From: Amanda Scholes on behalf of Planning.Responses
Sent: 01 February 2018 09:48
To: Planning Scanning
Subject: FW: LU/121/17/RES - Main Avenue Landscaping etc.
Importance: High

I do note that condition 7 of the outline consent does refer to the *overall* scheme, albeit requiring each phase to comply with the terms of the condition as-and-when submitted. Therefore, my comments here (and below) solely reply to the Main Avenue running E-W through the first part of the reserved matter application submitted under LU/121/17/RES.

From: Tim Townsend
Sent: 12 December 2017 16:23
To: 'Michael Eastham'
Subject: RE: LU/121/17/RES - Main Avenue Landscaping etc.

Please could I have your comments on the attached, amended Landscaping plan for Phase 2 of the residential development at North Littlehampton Strategic Development Area.

Tree Planting Details LA108

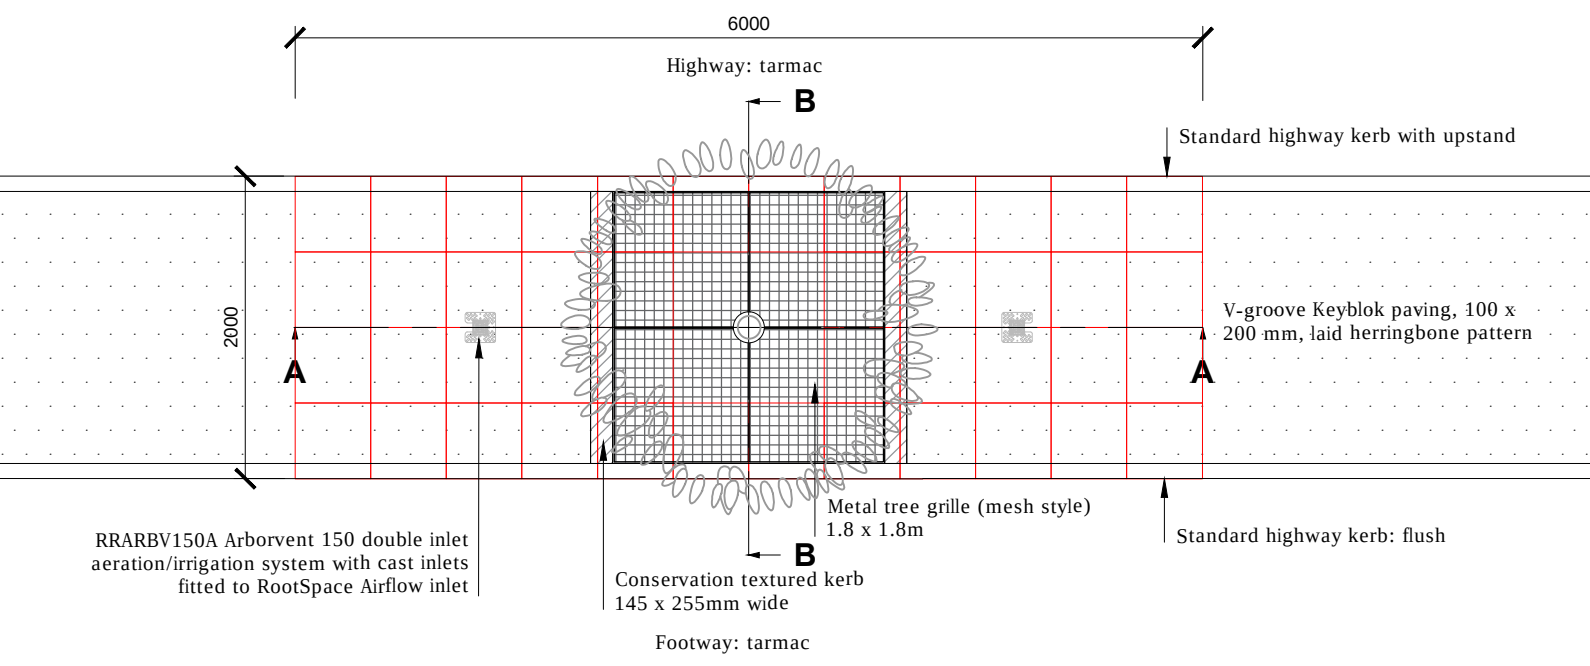
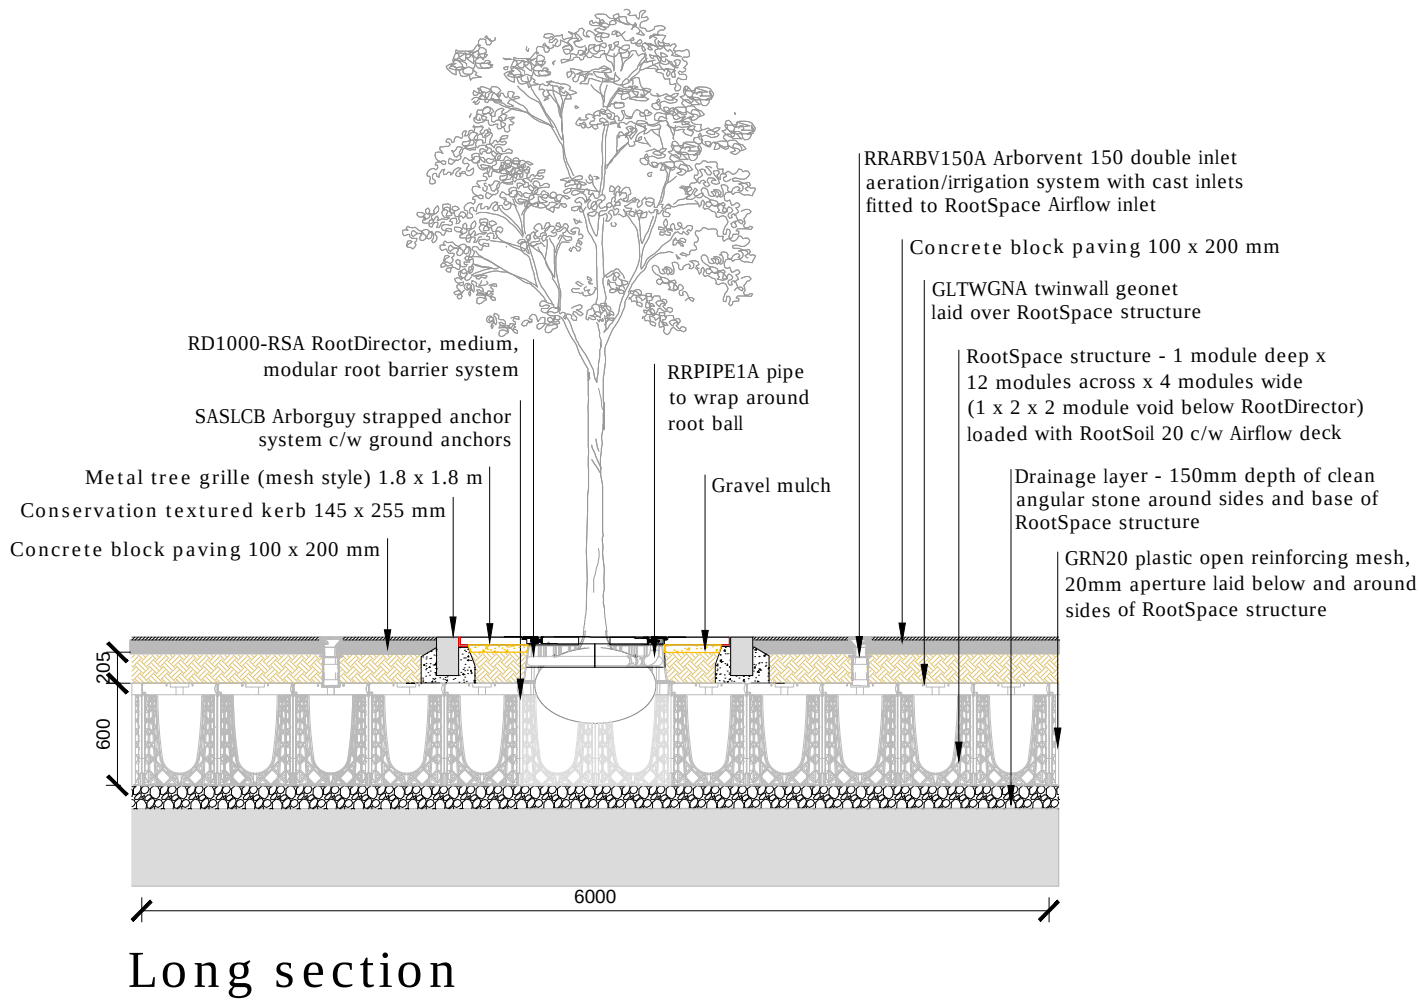
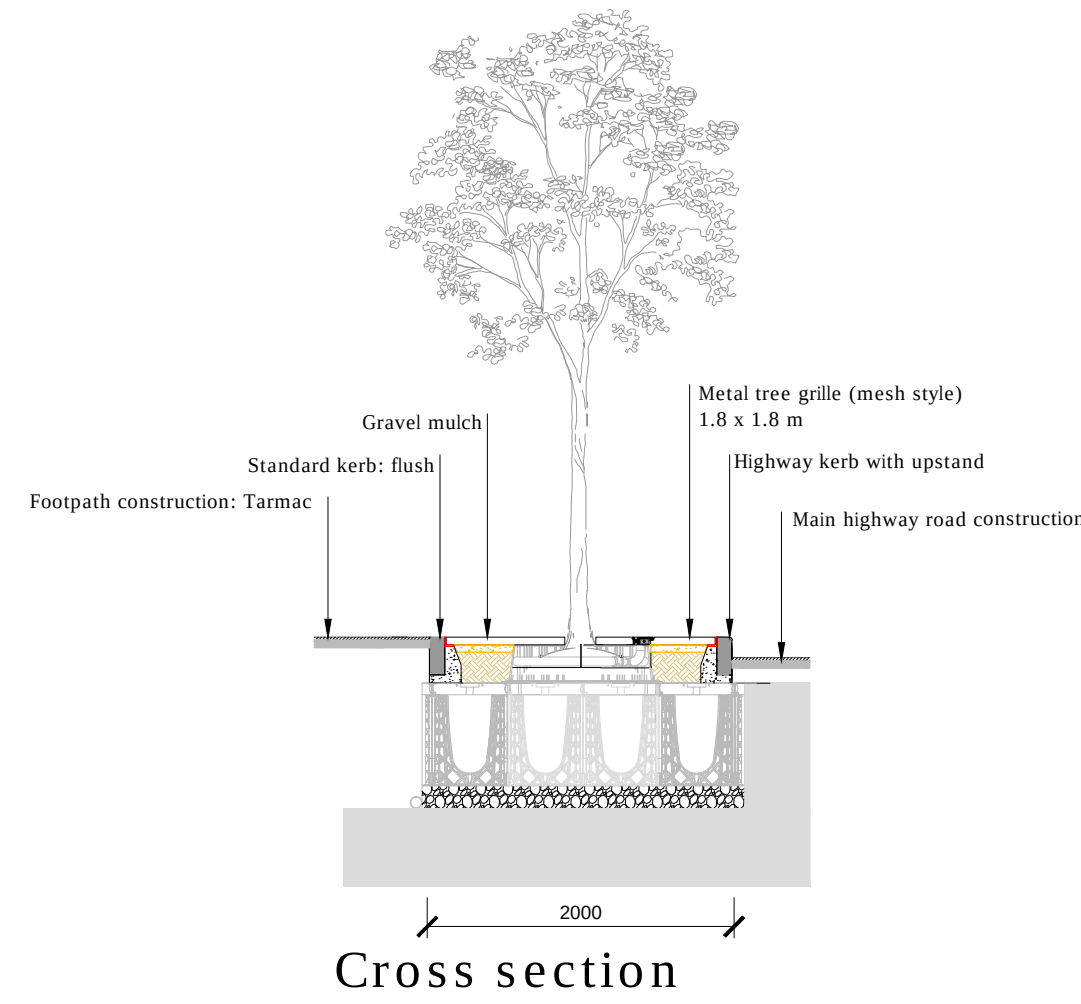
1. **Tree types** – must be clean (and narrow) stemmed up to 2.4m with no growth beneath when mature (to provide clearance for cyclists and pedestrians underneath).

2. **Street lighting** – Street lighting design and positions need to be considered carefully so as to not be obscured by tree canopies etc.
3. **Verge/hard landscaping areas** – A continuous verge would still be advantageous/preferred for tree root spread. Hard landscaping in-between trees can attract weeds etc. and might require additional maintenance (for which an additional commuted sum might be required). If used, Keyblok paving is acceptable to WSCC.

4. **Services** – must not run in verges nor hard landscaping areas where trees are proposed, nor roads (put them in footways/cycleways).
5. **Road Safety Audit (RSA)** – A Stage 2 RSA will be required at detailed design and/or S38/278 stage.

6. **Fencing in verge or hard landscaping areas** – this should not be provided for safety and maintenance reasons.
7. **Tree pits** – Design details of tree pits must be agreed at the detailed design/S38/278 stage prior to installation.

8. **Commuted payments** – Will be required for tree and pit maintenance (will be worked-out at detailed design stage).
